From: Phil Jones <phil@pjep.com.au>
Sent: Wednesday, 2 December 2020 8:39 AM
To: 'Ania Dorocinska'
Cc: 'Owen Walsh'
Subject: Sydney Business Park - Stage 3 SSD Updated Final Plans

Please find below a link to the updated final plans for the Sydney Business Park Stage 3 SSD, which address the additional comments from Council and TransGrid:

LONGITUDINAL SECTION - HOLLINSWORTH ROAD SCALE 1:500 (H) SCALE 1:100 (V)

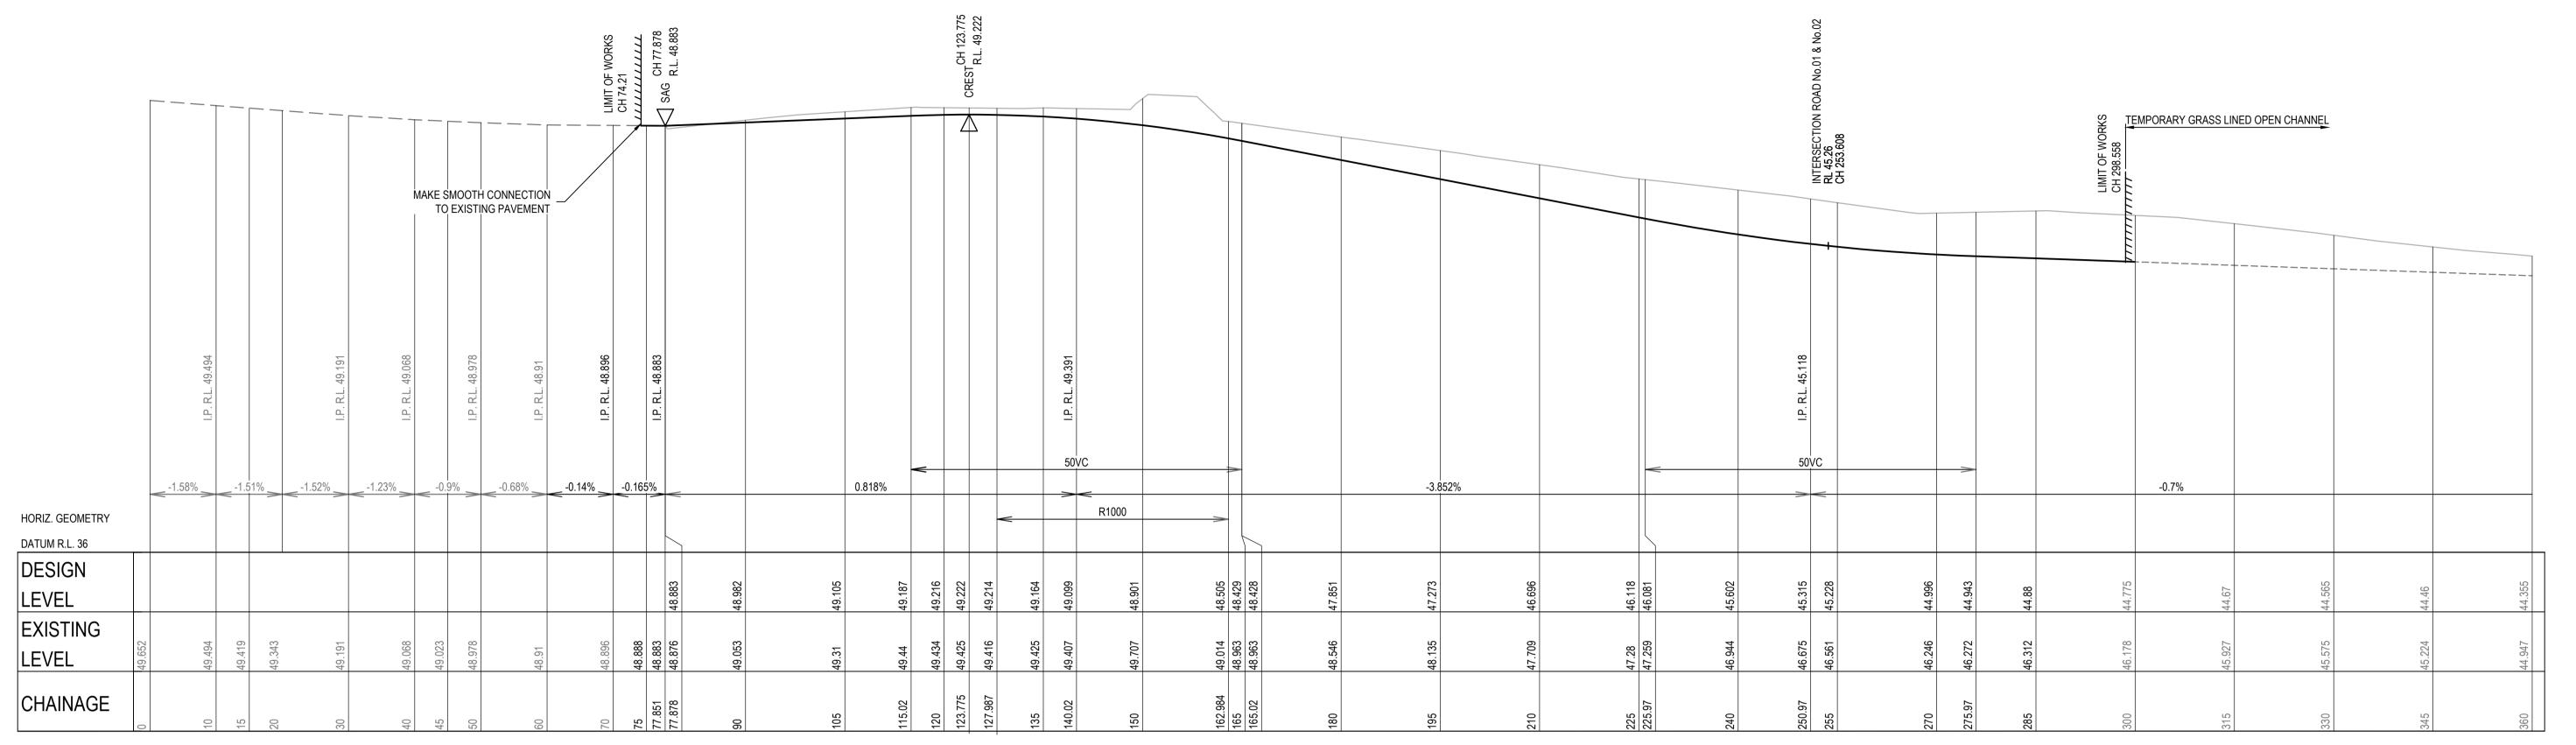
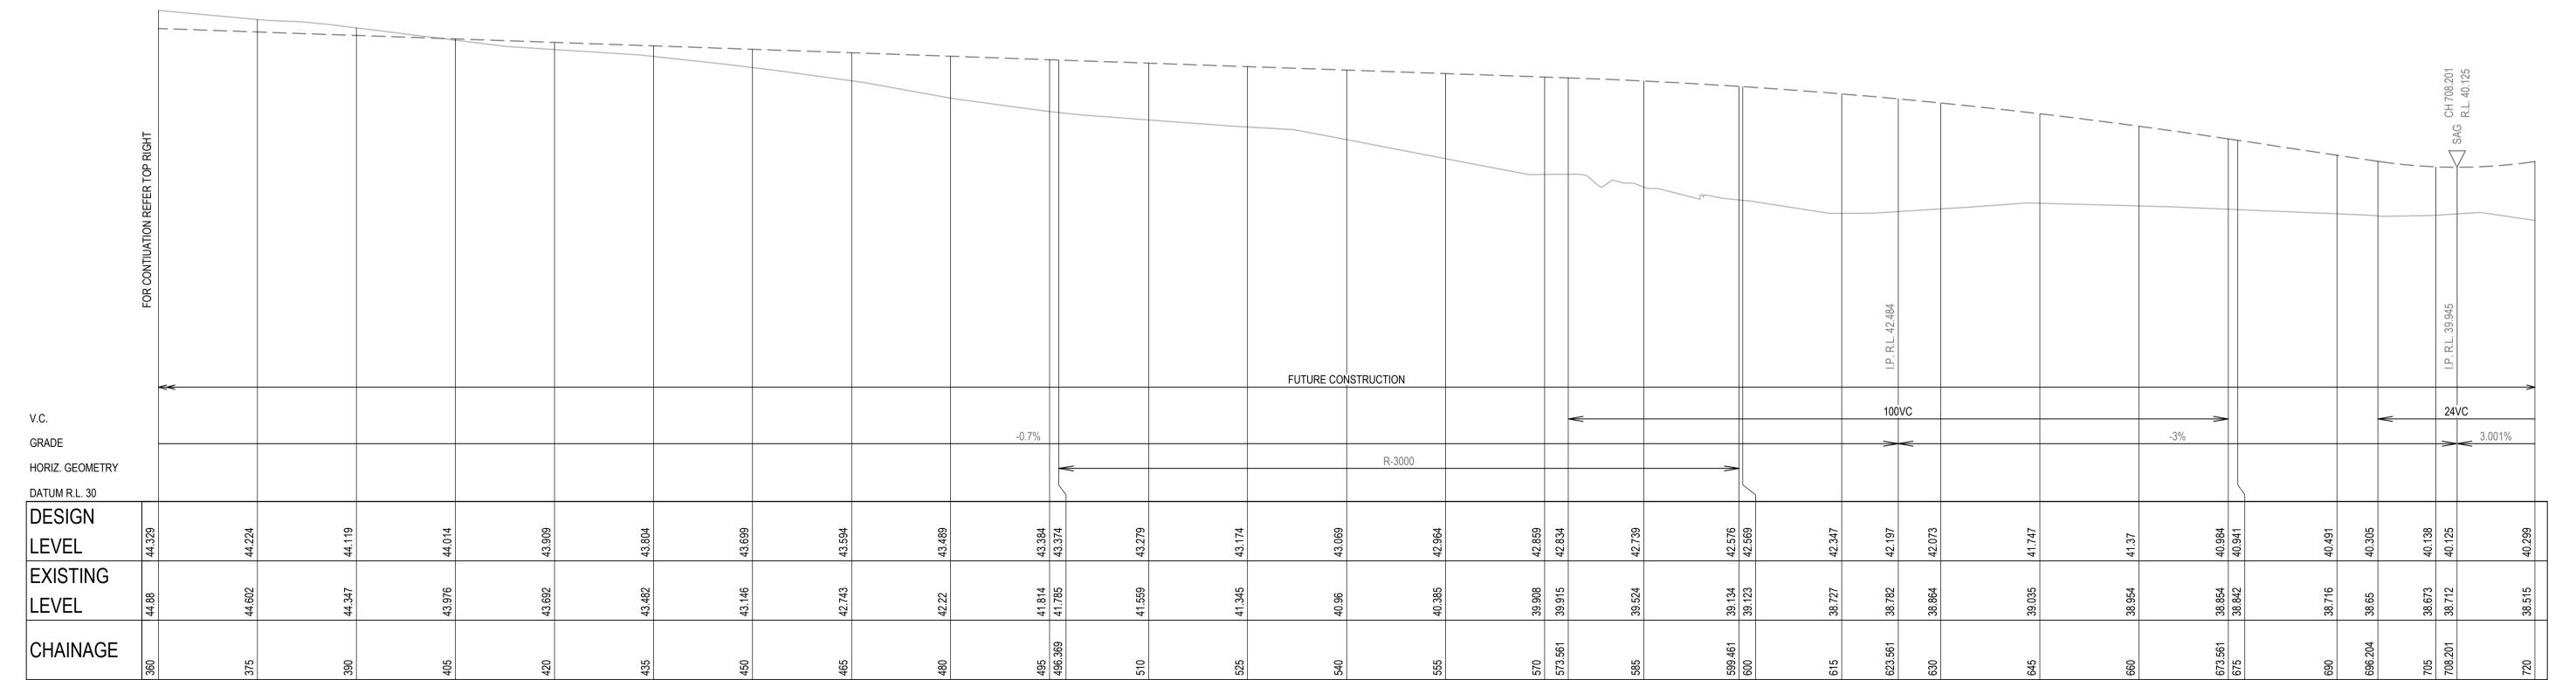
- Hollinsworth Road interface with existing has been updated to reflect works as executed information available; and
 - Basin A maintenance access turn head has been updated to reflect agreement between Council and TransGrid.

### STORMFILTER CARTRIDGE (CAST IN-SITU VAULT 28 690mm ZPG CARTRIDGE) PLAN - WAREHOUSE 2

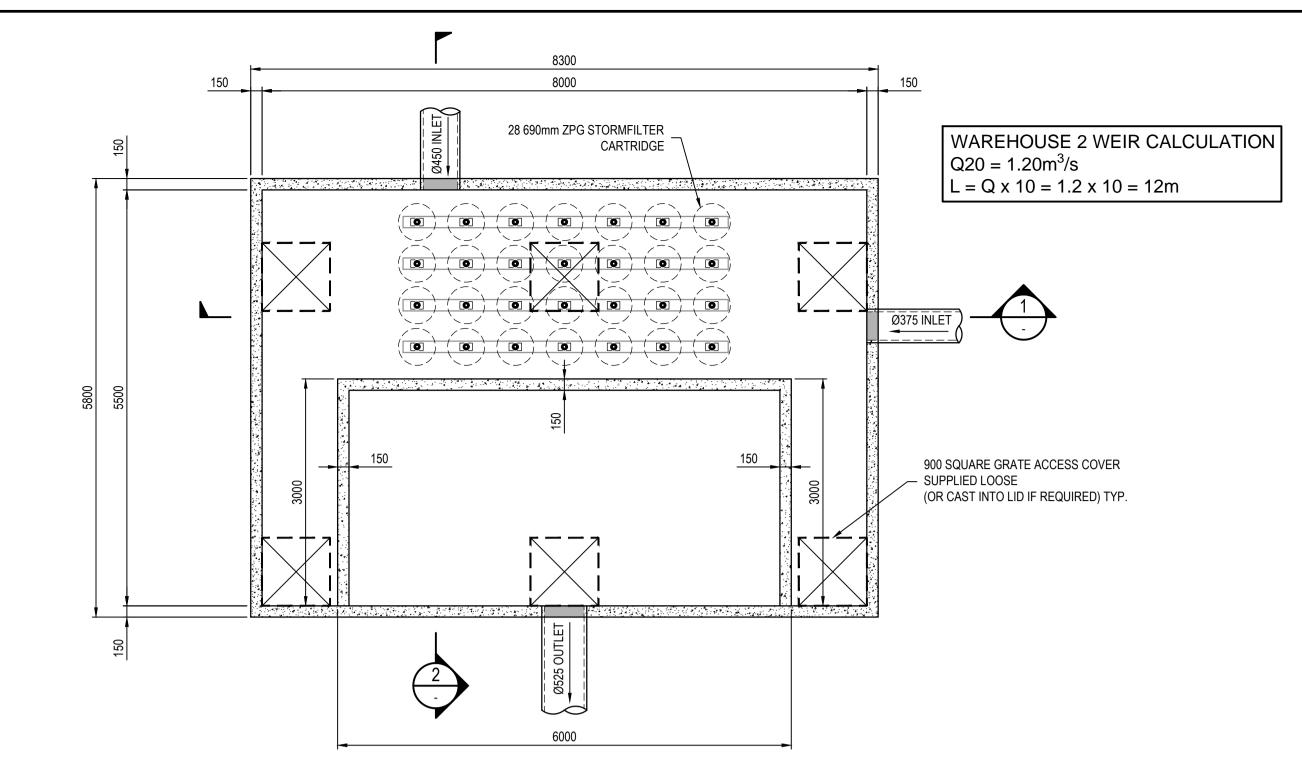
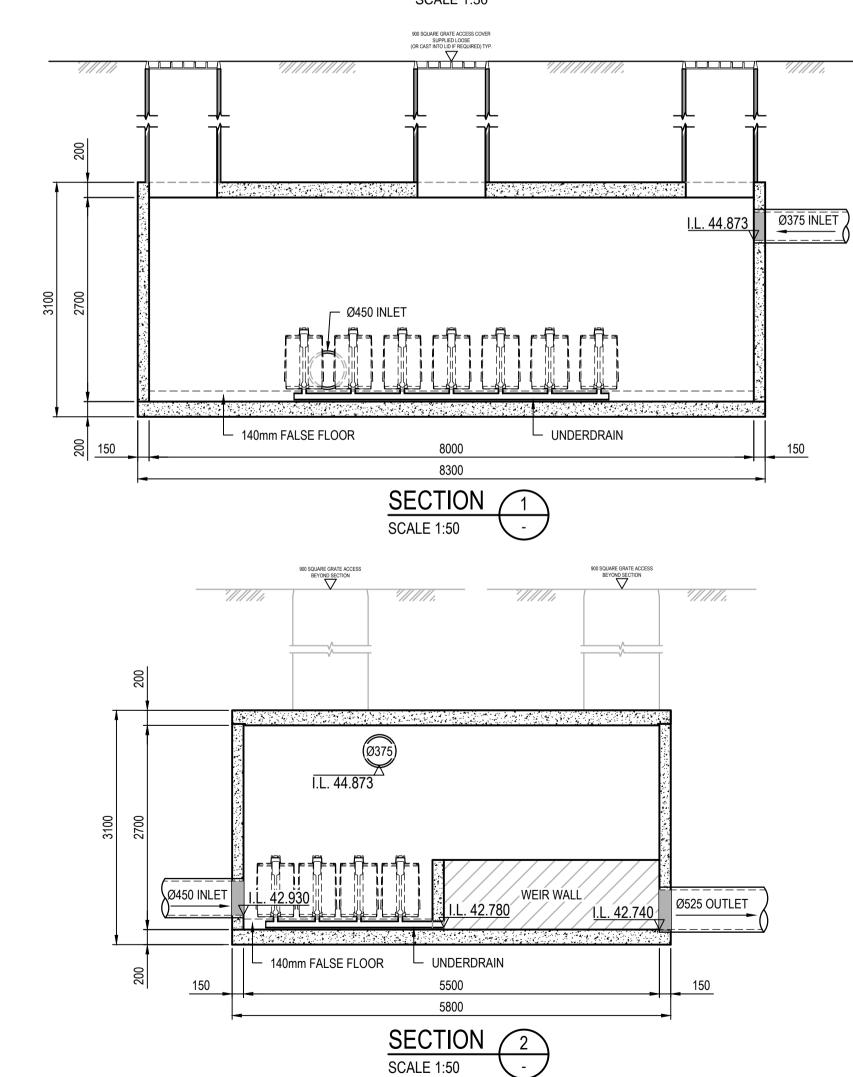
- Road plan chainages have been corrected to avoid confusion;
 - Bioretention treatment at Warehouse 2 has been deleted and a treatment tank has been adopted to meet TransGrid requirements;

FORCE	אופווע	OCTION		
Title:		RIM BASIN ECTIONS	I A	
Project No.	Set No.	Milestone	Plan	Revi
20-0127	02	DA	502	F

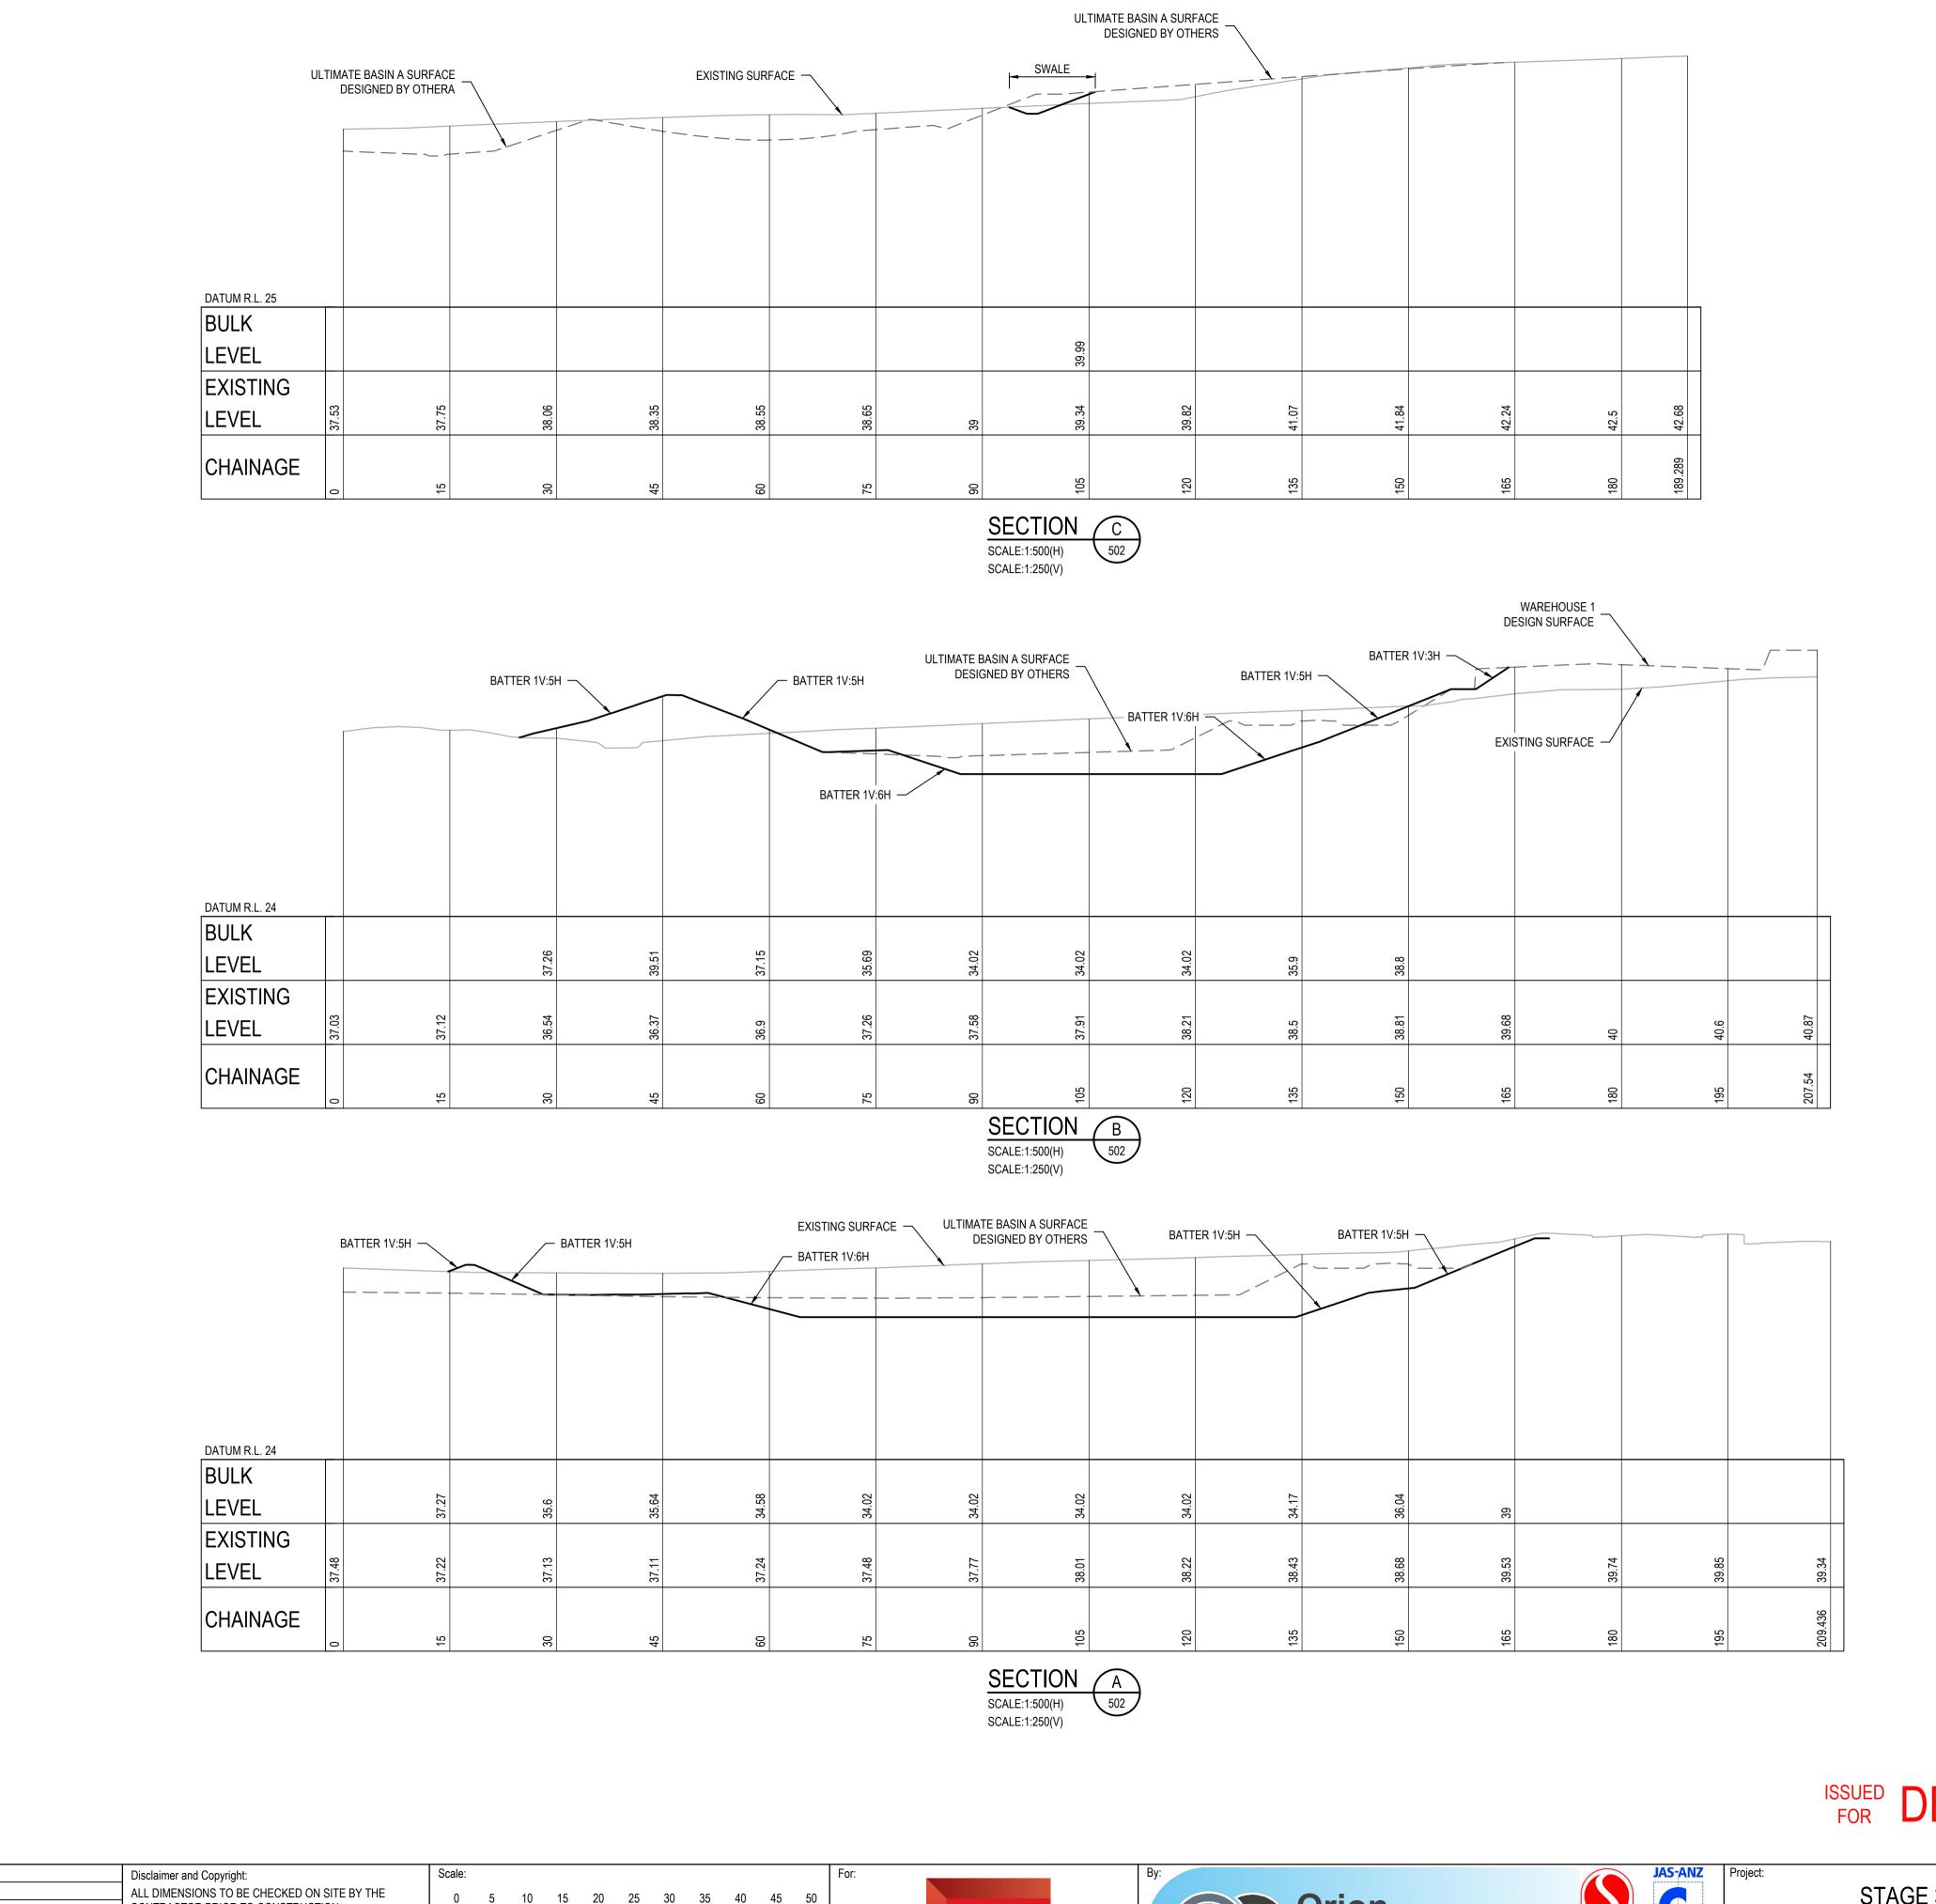
- Civil plans:
 - Rising main and pump station has been added to Basin A (to show intent in the event that the diversion drain is not operational);
 - Redundant easements have been removed from the plans;
